## **OXFORDSHIRE COUNTY COUNCIL'S RESPONSE TO CONSULTATION ON THE FOLLOWING DEVELOPMENT PROPOSAL**

**Application no:** 21/03195/F

**Proposal:** Formation of surface car park and service building (including substation, sprinkler tanks and EV charging infrastructure)

**Location:** Begbroke Science Park, Begbroke Hill, Begbroke, OX5 1PF

CAR PARK FOUL AND SURFACE WATER DRAINAGE LAYOUT

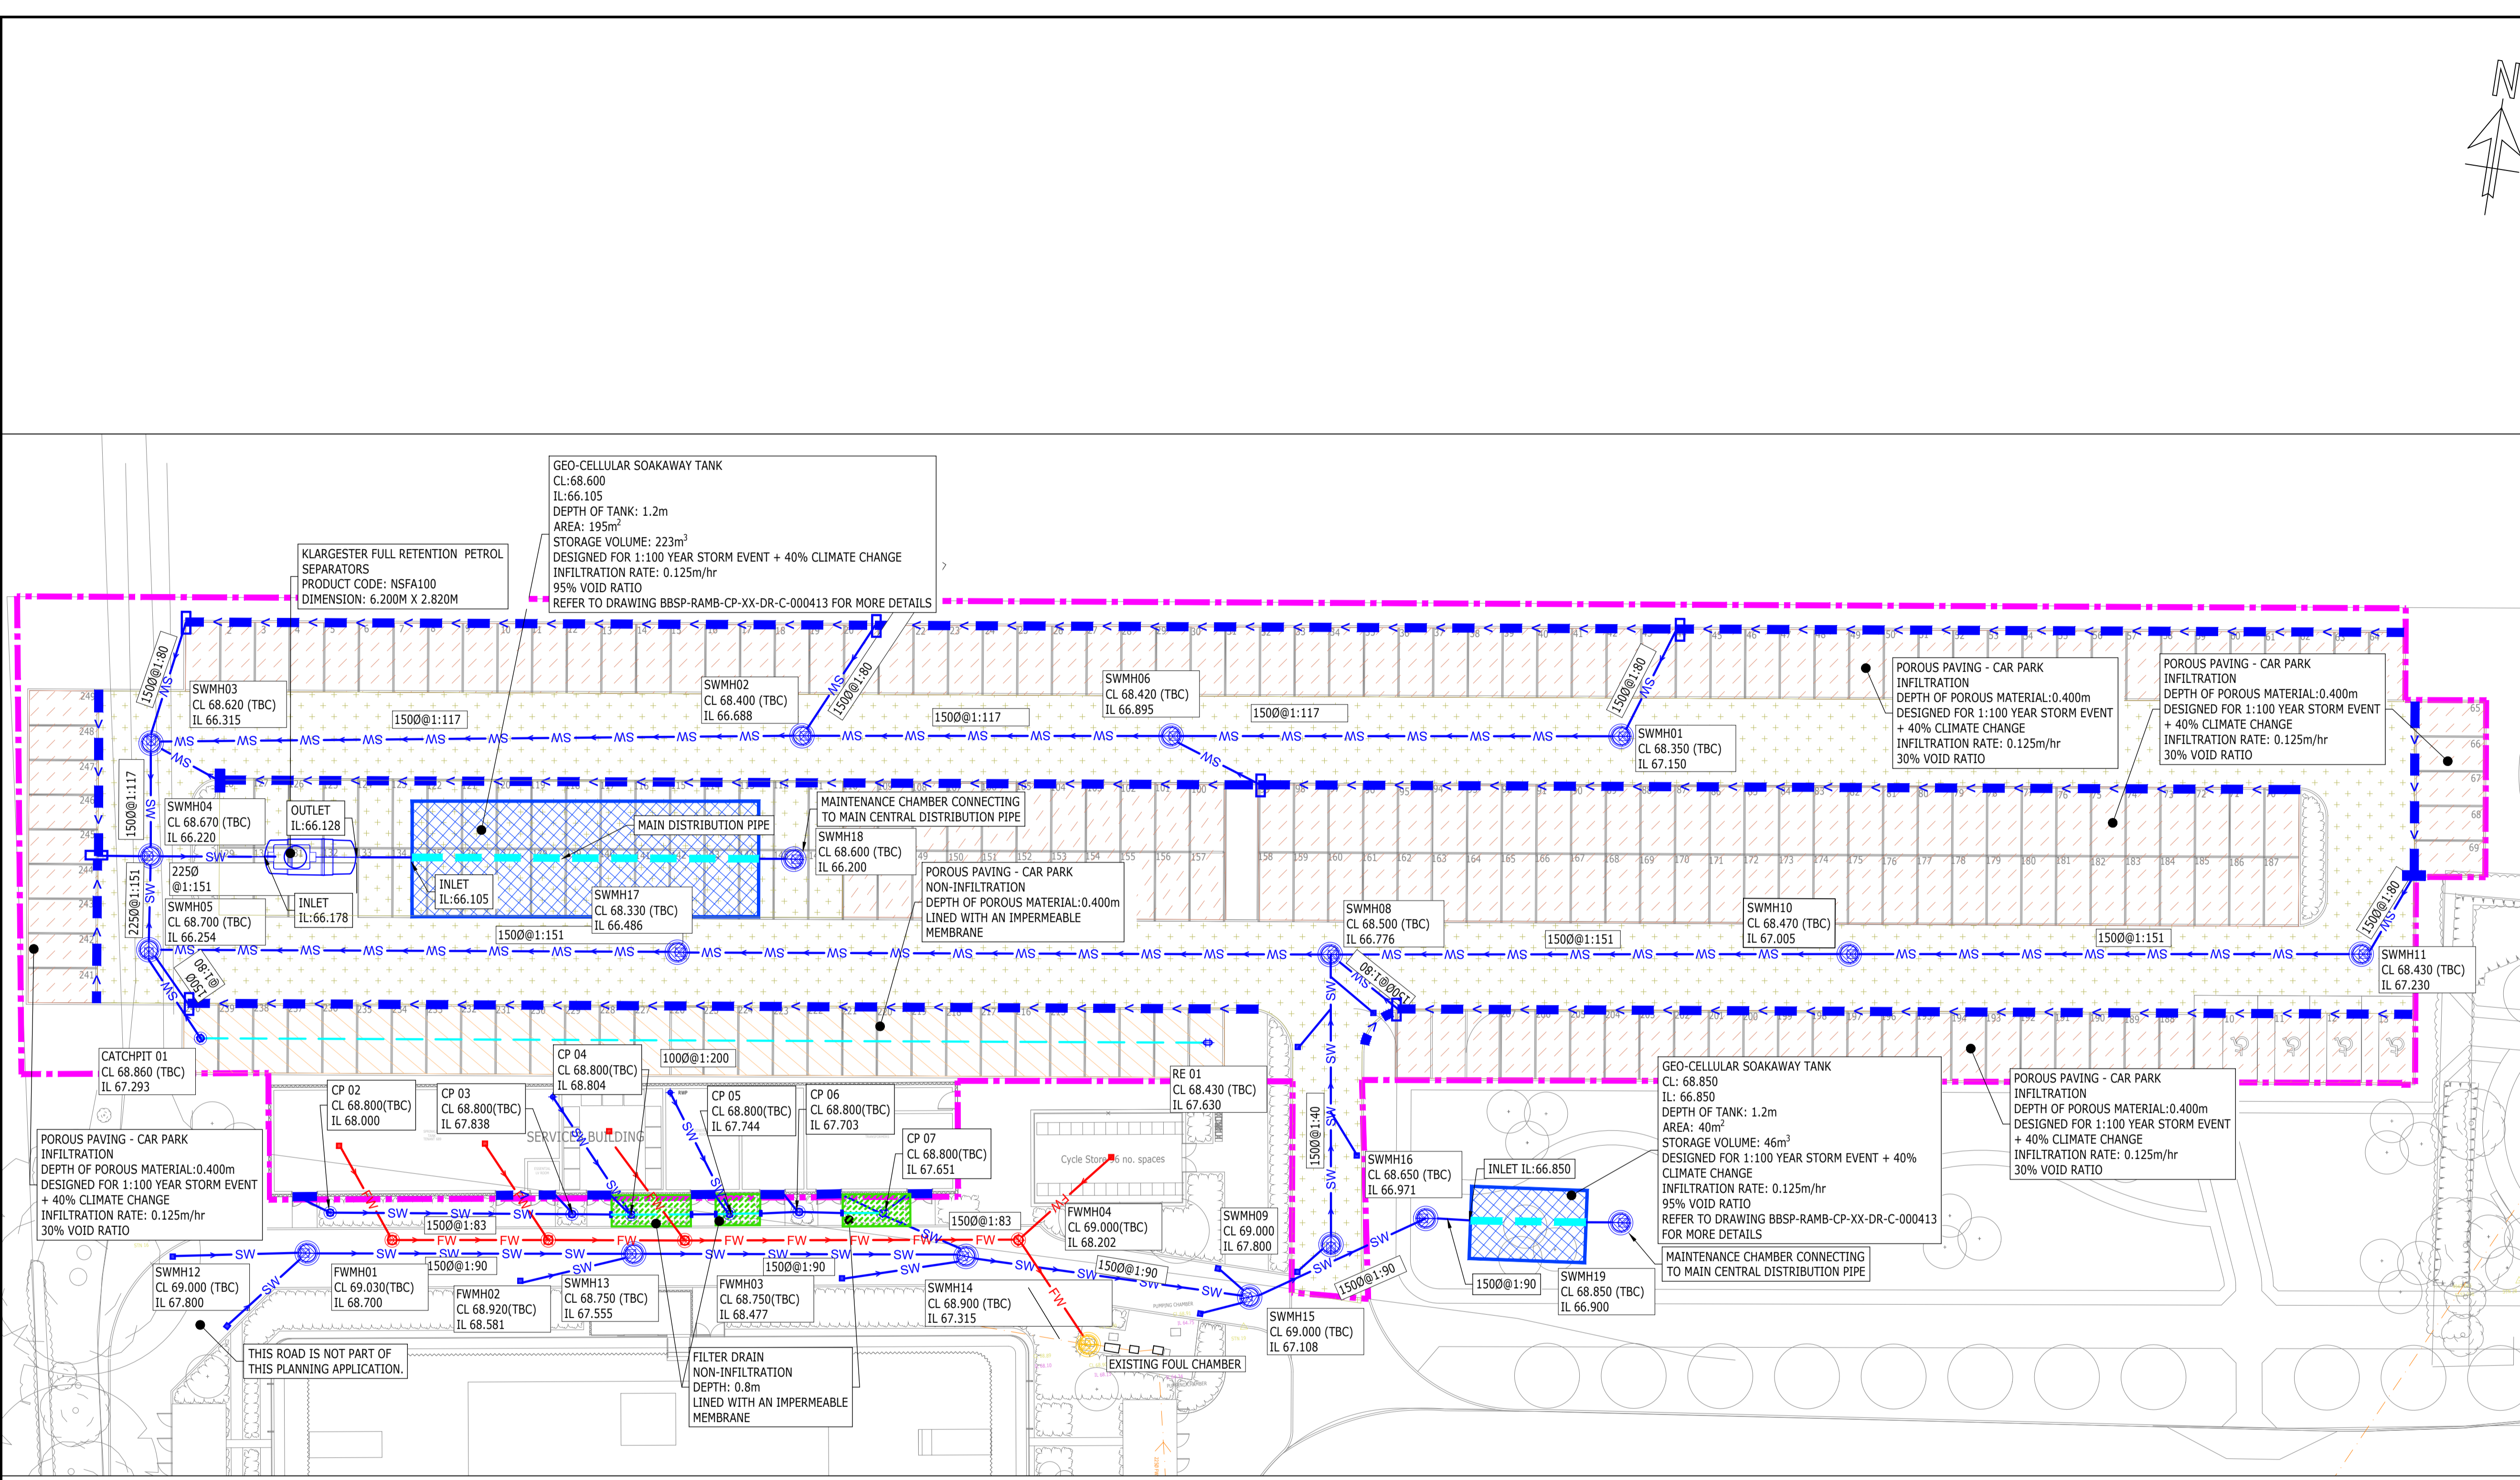
The approved drainage system shall be implemented in accordance with the approved Detailed Design prior to the use of the building commencing:

BBSP-RAMB-CP-XX-RP-C-000001

Surface Car Park Drainage Statement
